Planning Application No: 3/2026/0156

Proposal: Proposed detached garage.

Location: Highfield Garstang Road Chipping PR3 2QH

project	Highfield	project number	26.11	drawing number	PL.03
title	Construction Management Plan				
scale	1 to 200 @ A3	date	March 2026	status	planning
				revision	A

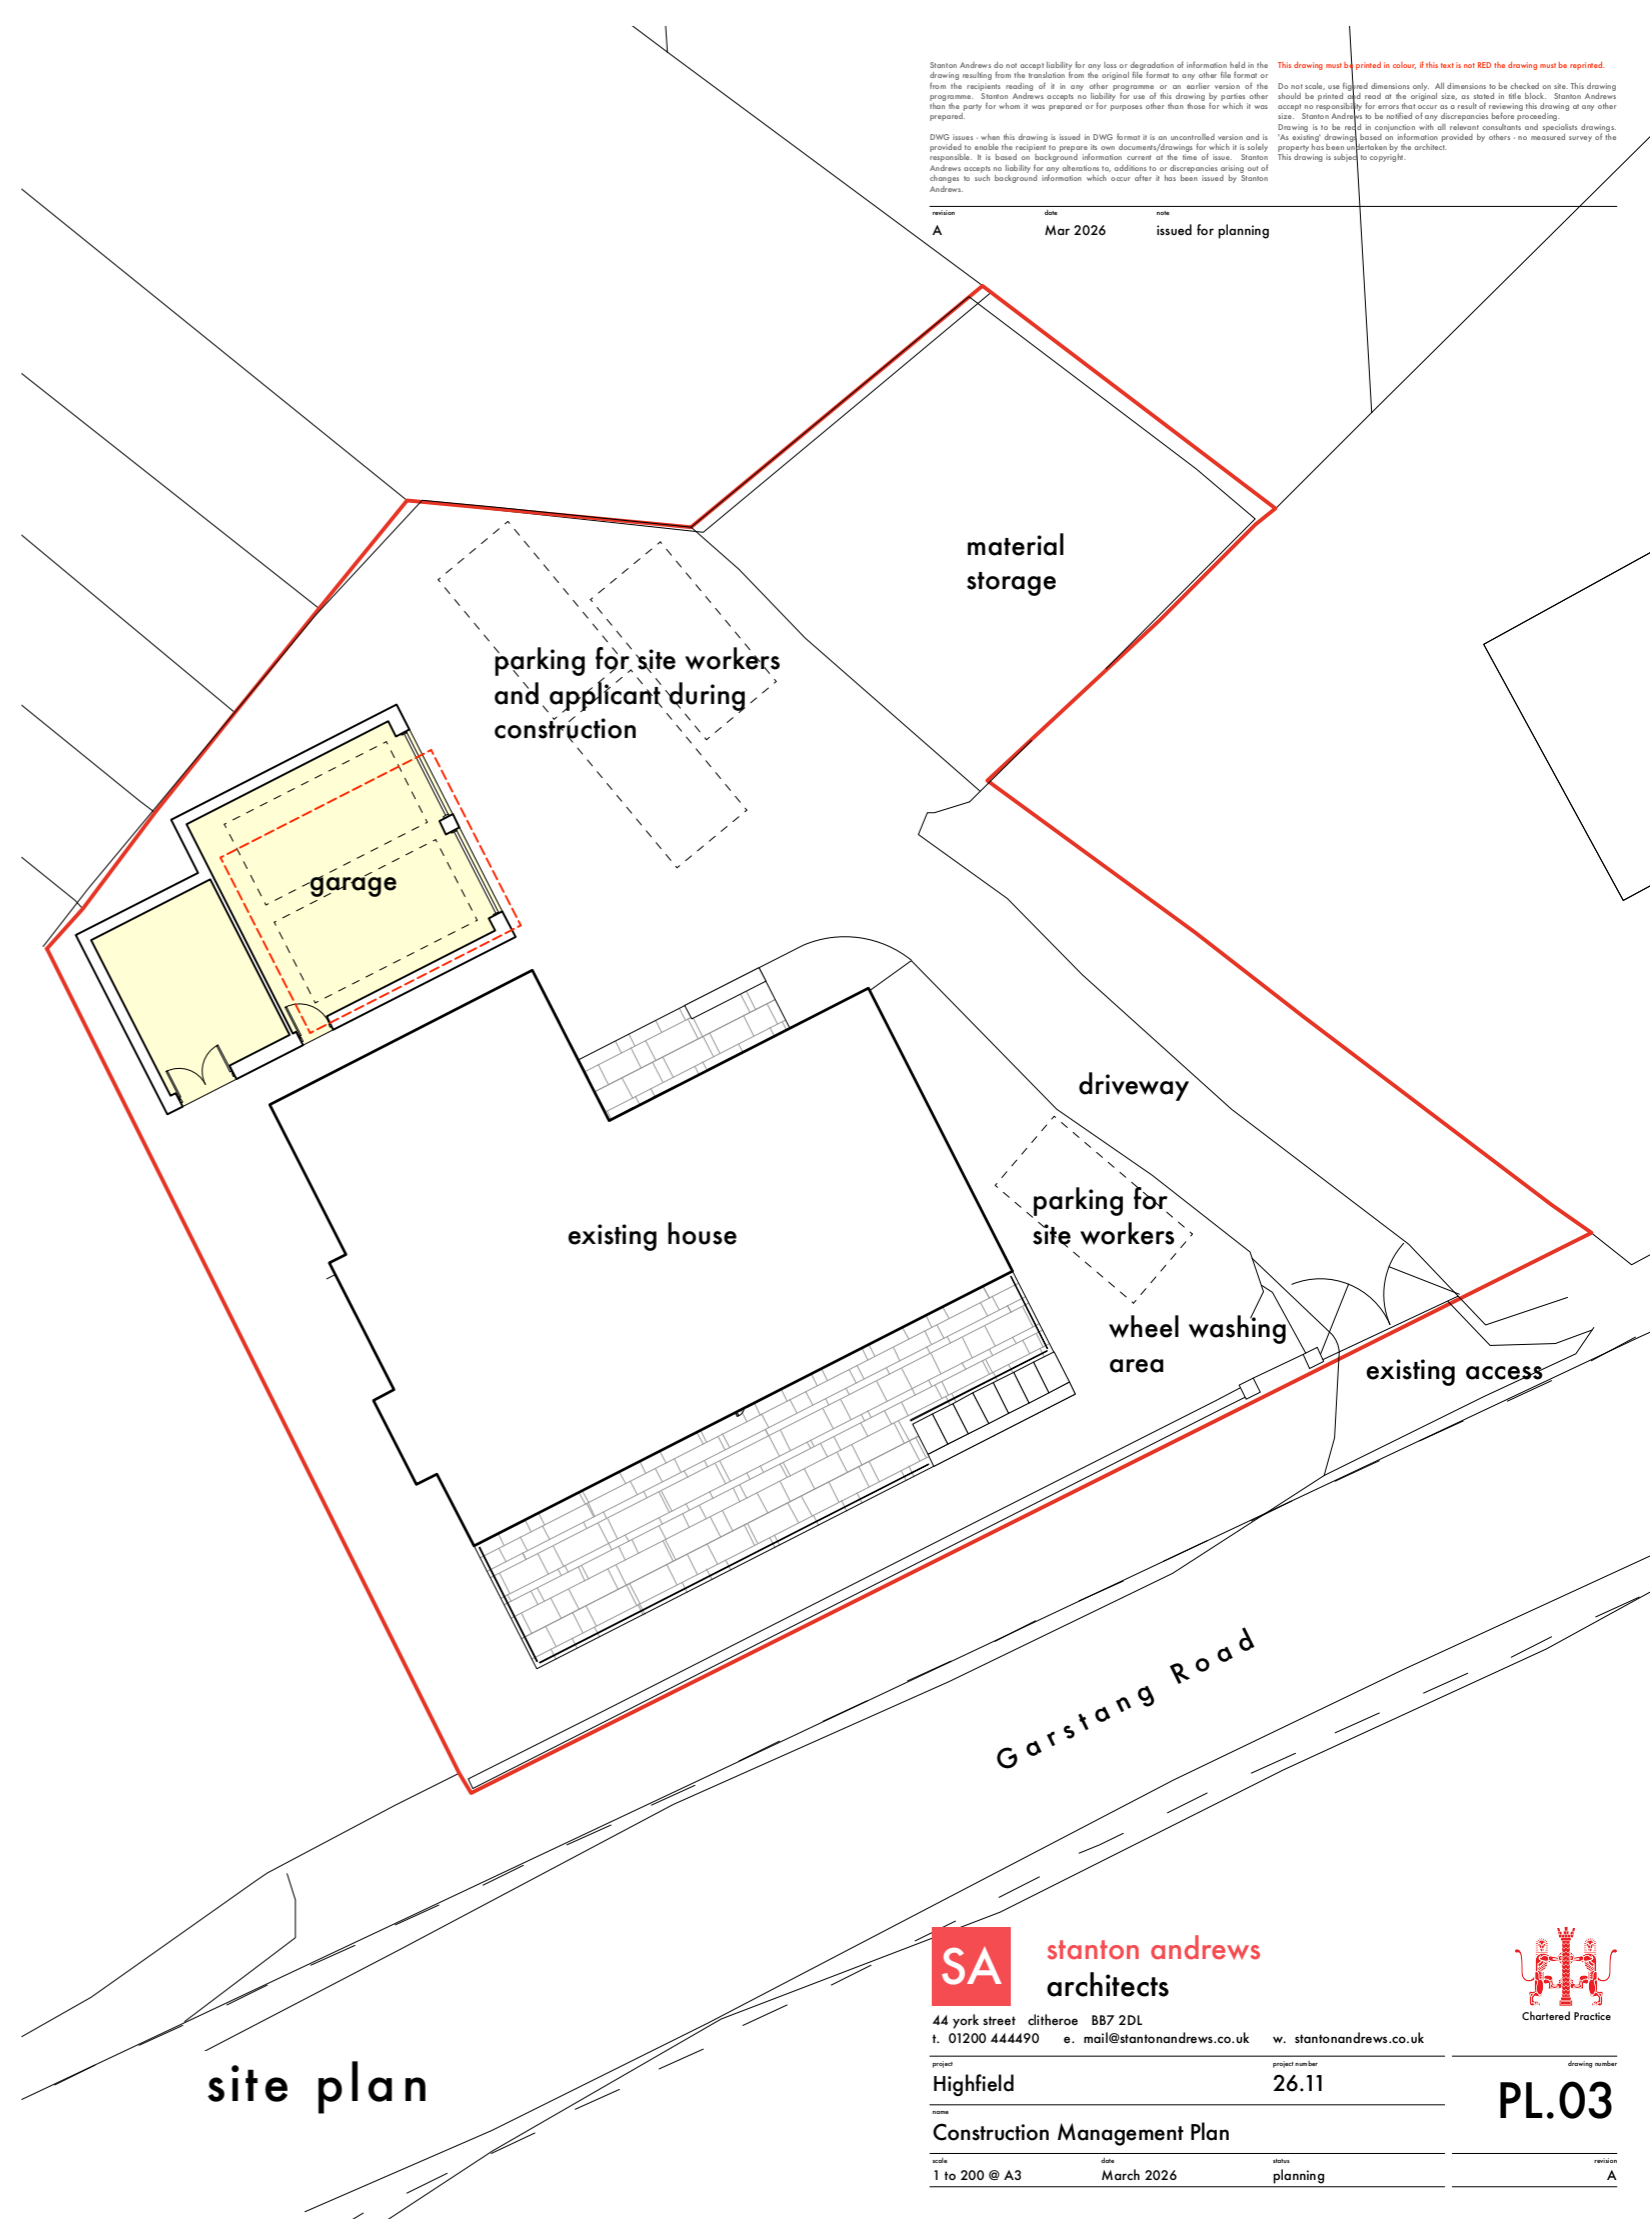
As Garstang Road has a 60 mph speed limit, a construction management plan is required to alleviate any highway safety concerns during the construction period.

- The detached garage hereby approved shall be kept available for the parking of vehicles ancillary to the enjoyment of the household and shall not be used for any use that would preclude the ability of their use for the parking of private motor vehicles, whether or not permitted by the provisions of the Town and Country Planning (General Permitted Development) Order 2015 or any order amending or revoking and re-enacting that order. Reason: To ensure that adequate parking provision is retained on site.
- Prior to work starting on site a construction management plan is produced for approval. This should highlight how deliveries during construction will be managed and where workers on the site will park during construction. Reason: to minimise the impact of construction on existing residents and pedestrians in the vicinity of the site.

proposed site plan

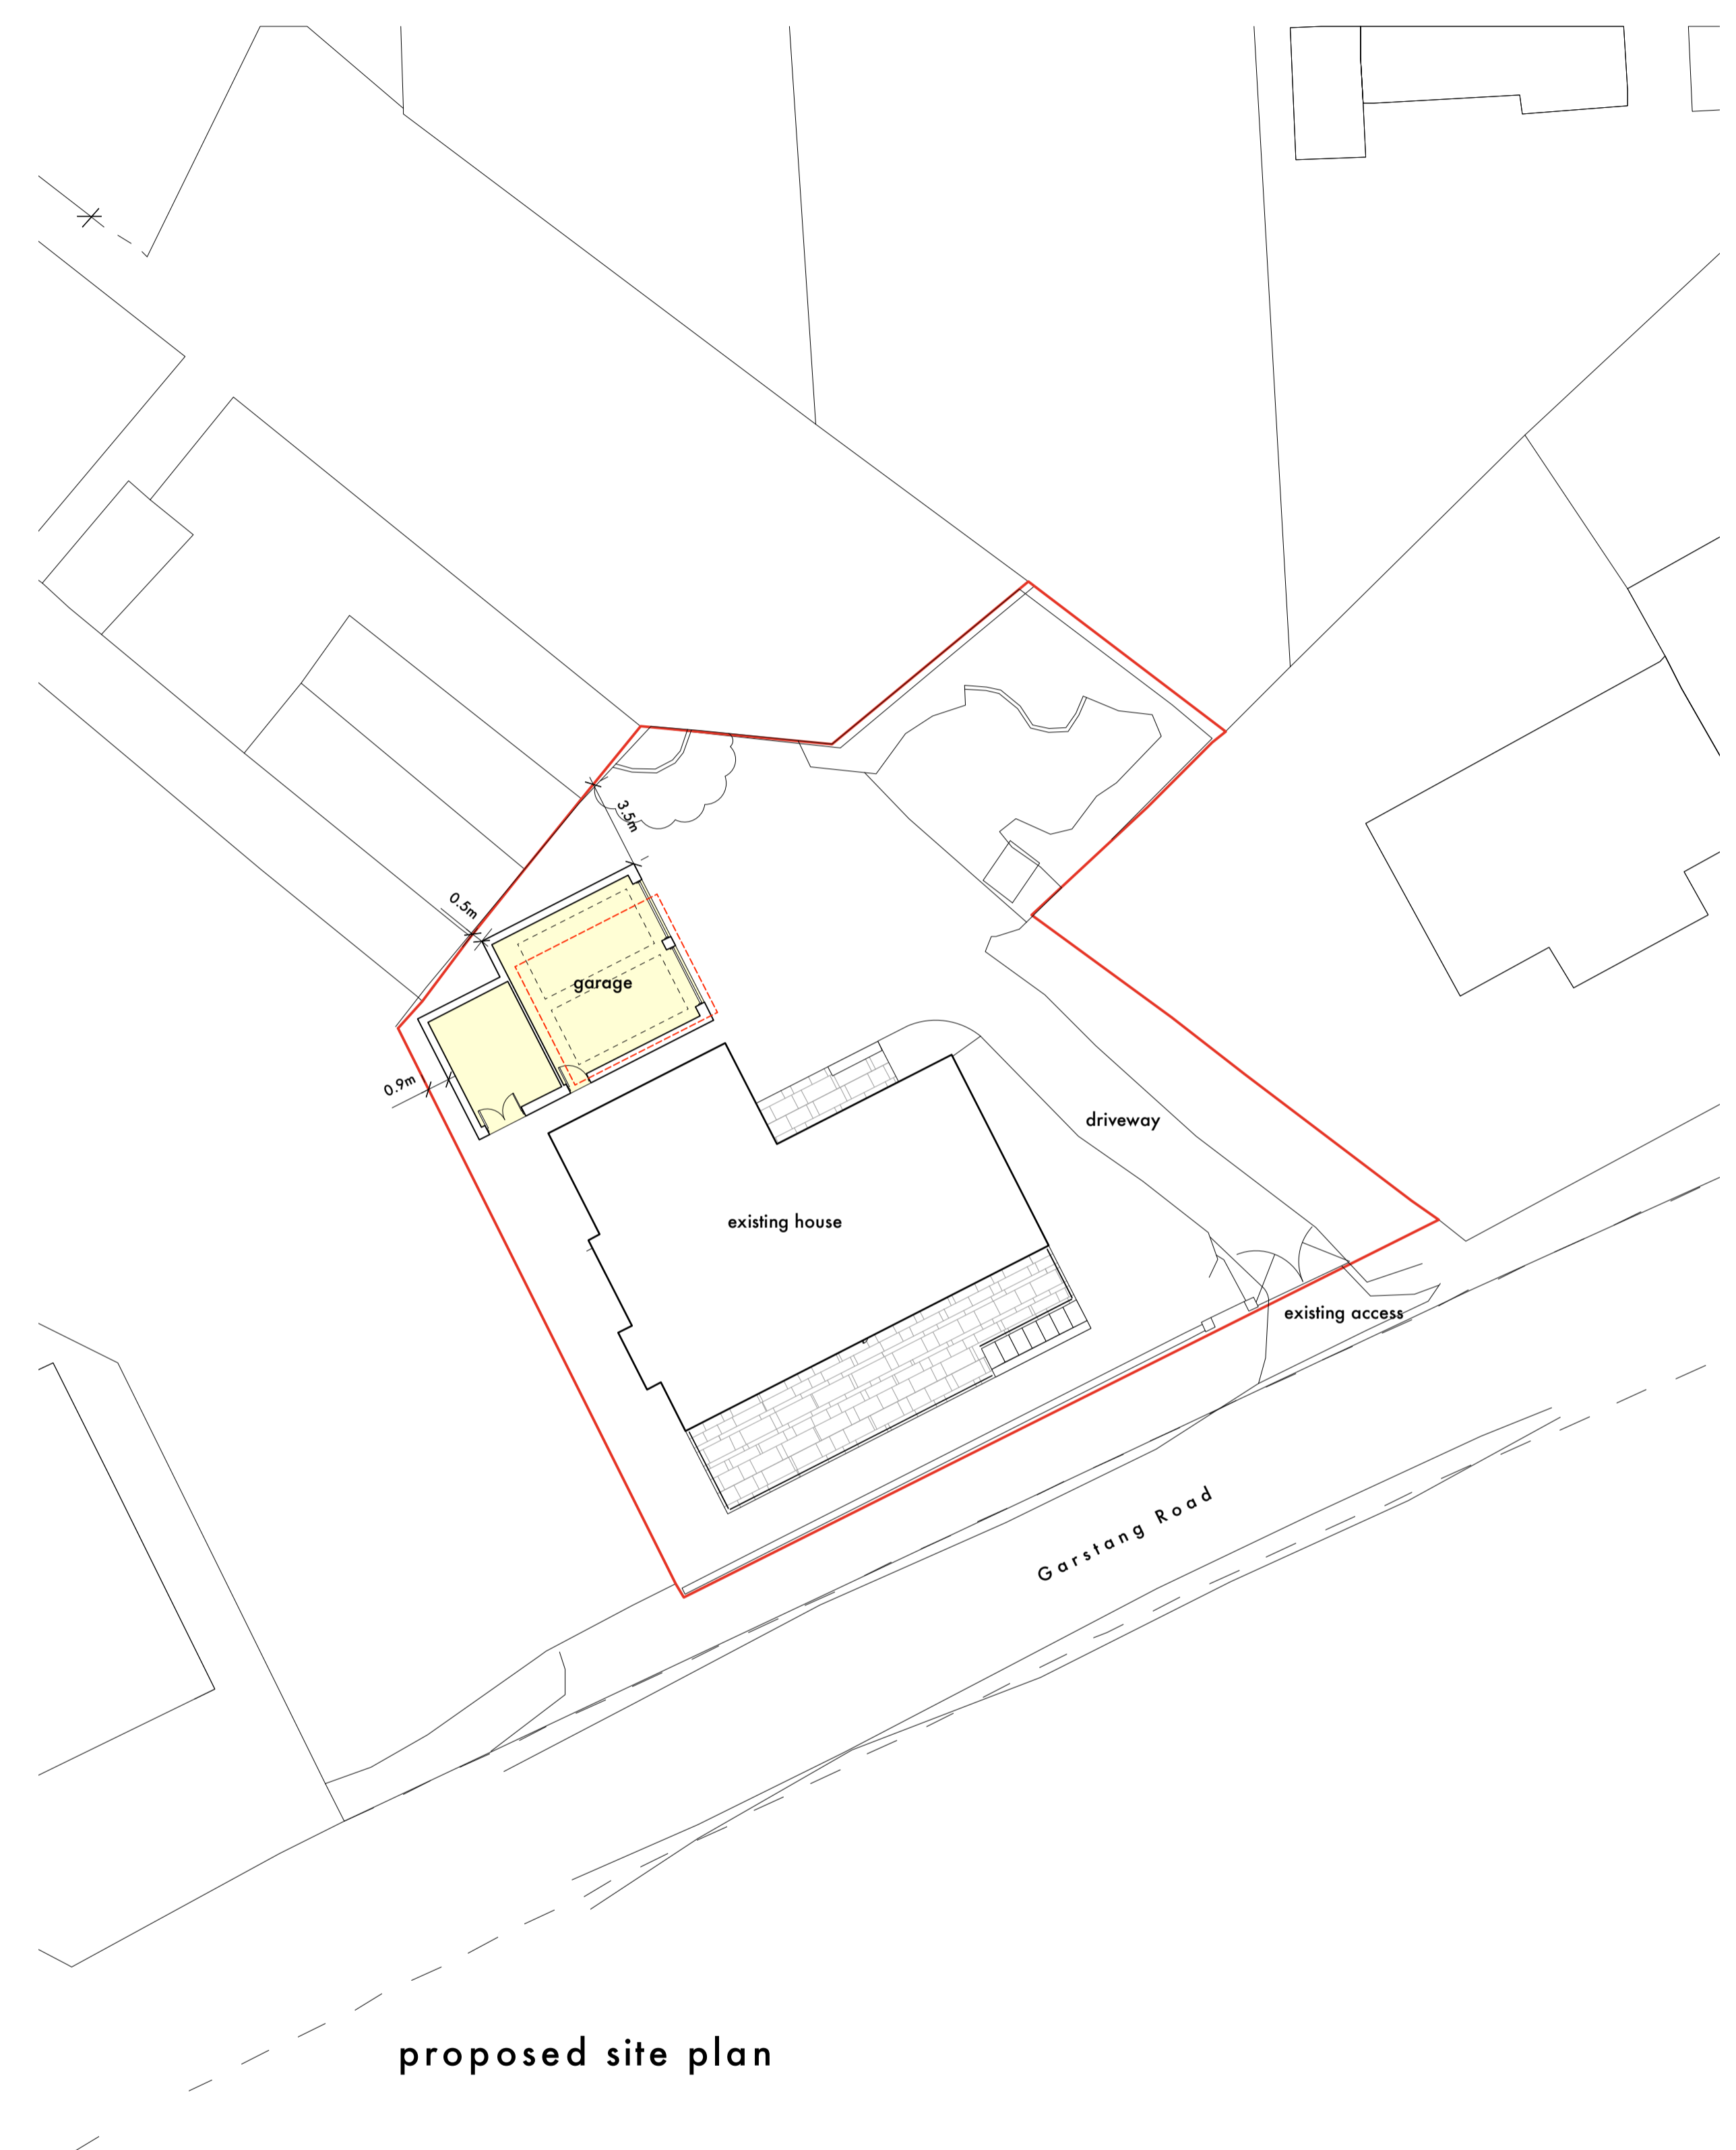
- The parking (and manoeuvring) area(s) shall thereafter always remain available for parking of vehicles associated with the dwelling. Driveways/vehicle parking areas must be properly consolidated and surfaced in bound porous materials, (not loose stone, gravel or grasscrete) and subsequently maintained in good working order at all times thereafter for the lifetime of the development. Reason: To ensure satisfactory levels of appropriately constructed off-street parking are achieved within the development and to avoid unnecessary parking on the highway to the detriment of highway safety.
